AB/112/25/L

17A High Street Arundel BN18 9AD

Listed building consent for revised porch design following permission AB/10/25/L.

Project	Drawing	Scale	Drawing No	Date
17A High Street, Arundel	Proposed Floor Plans - RevB	1:50 @ A3	1006 - DPA - 003	20.08.25

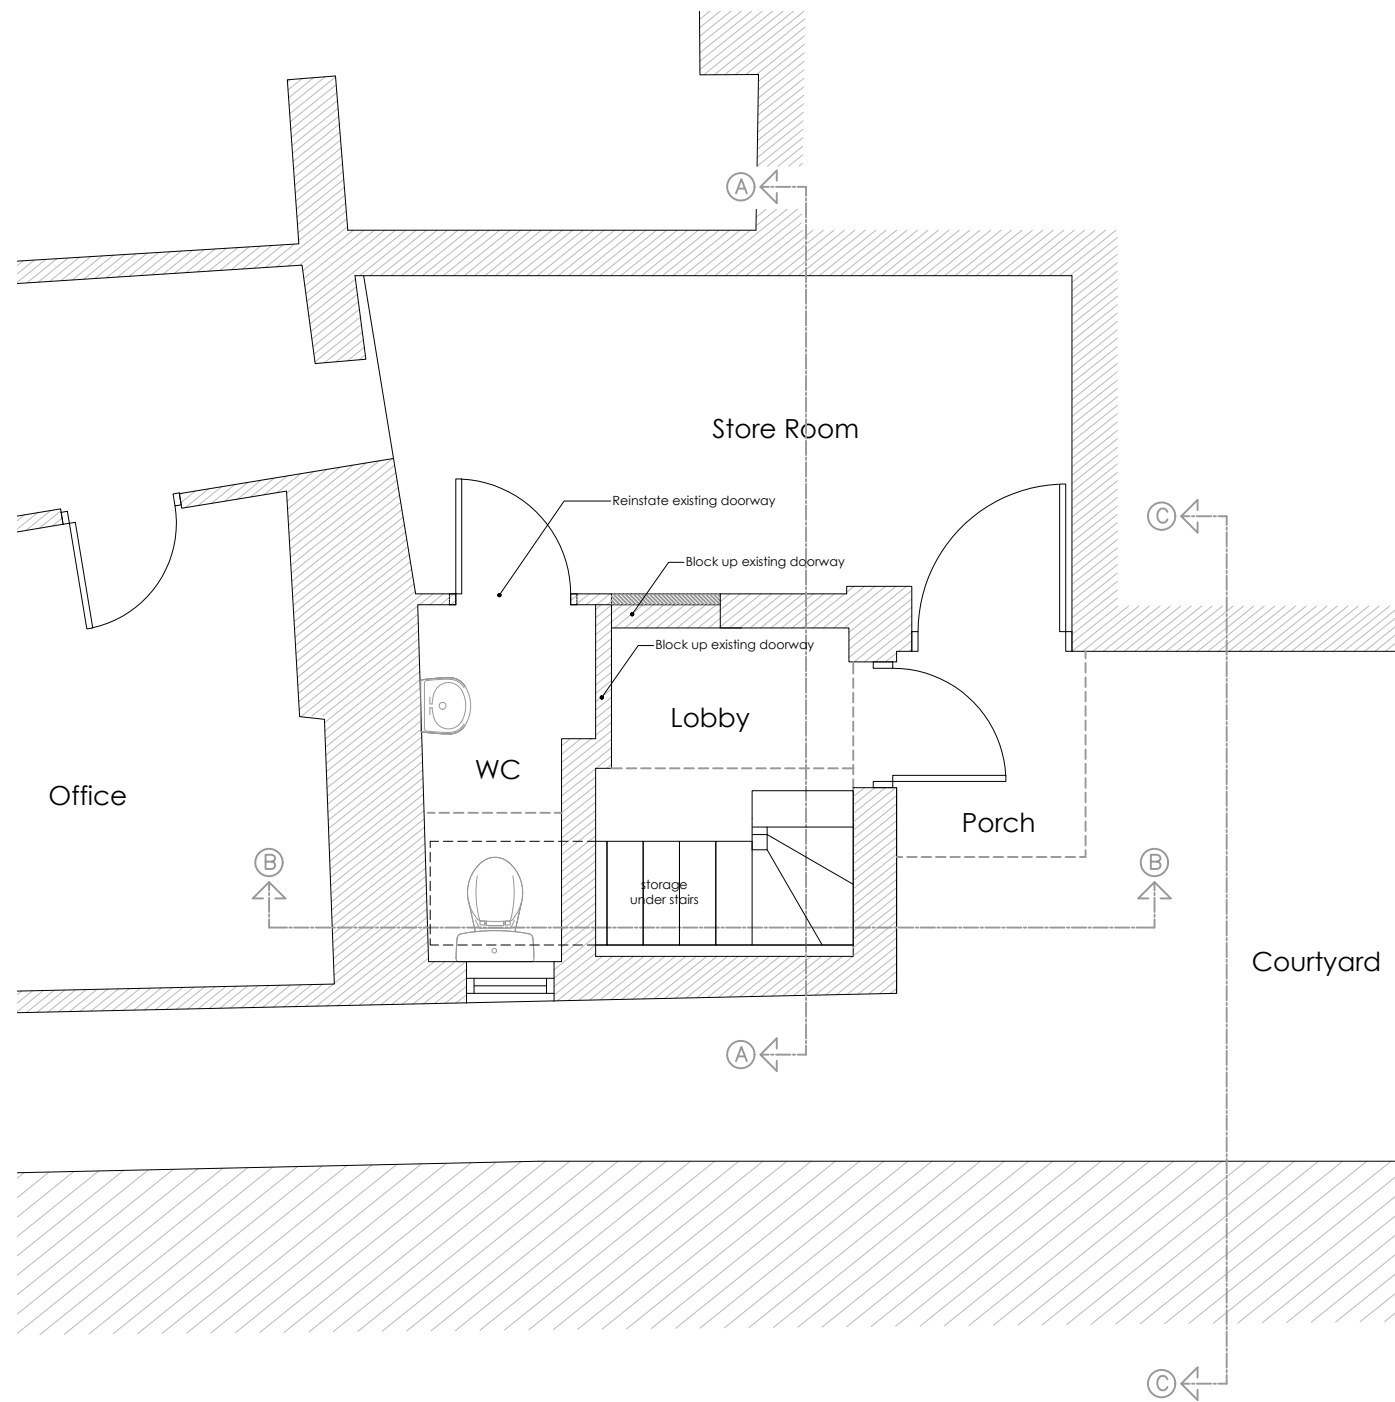
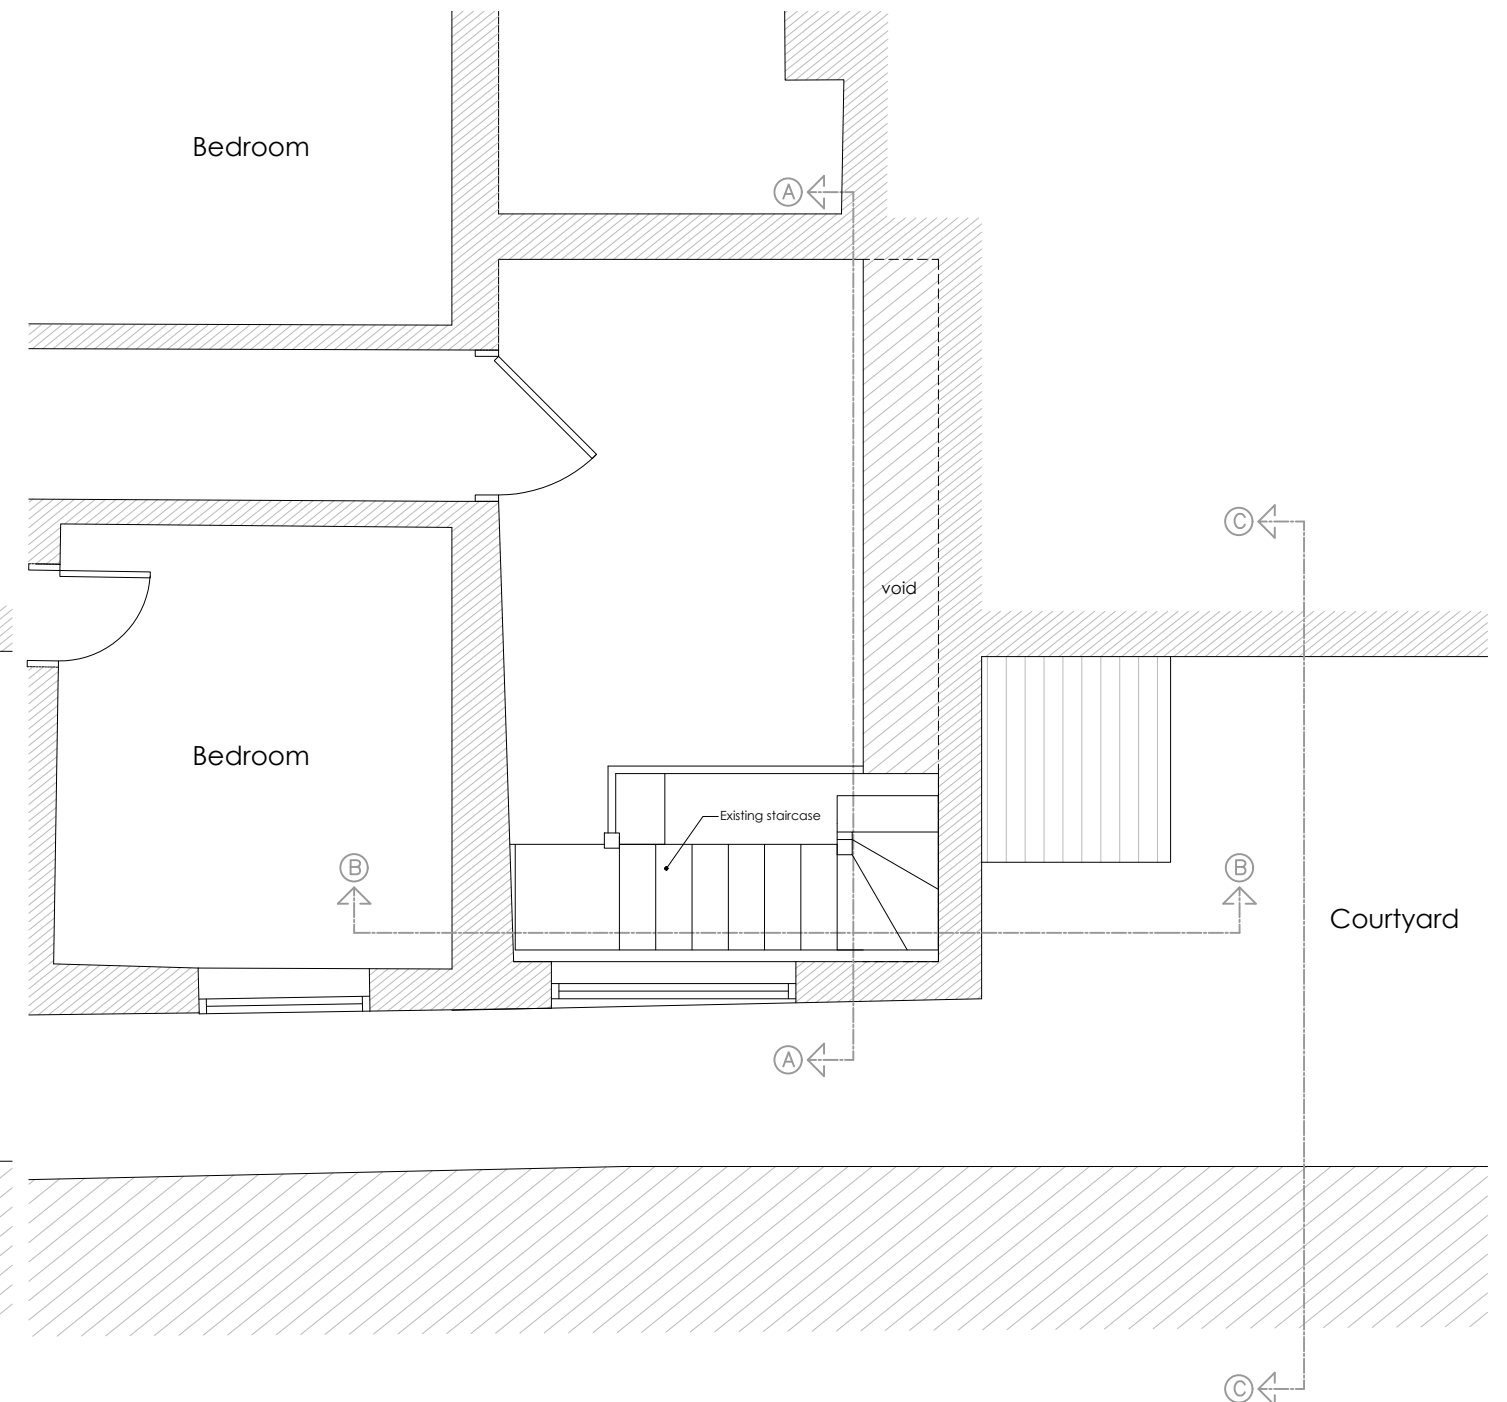
The proposal is for a revised porch design, following a previously approved scheme (ref: AB/10/25/L). I consider the revised design to be acceptable and not harmful to the special interest of the listed building. Although, it would be helpful to understand how the timber would be finished – would it be stained or painted?
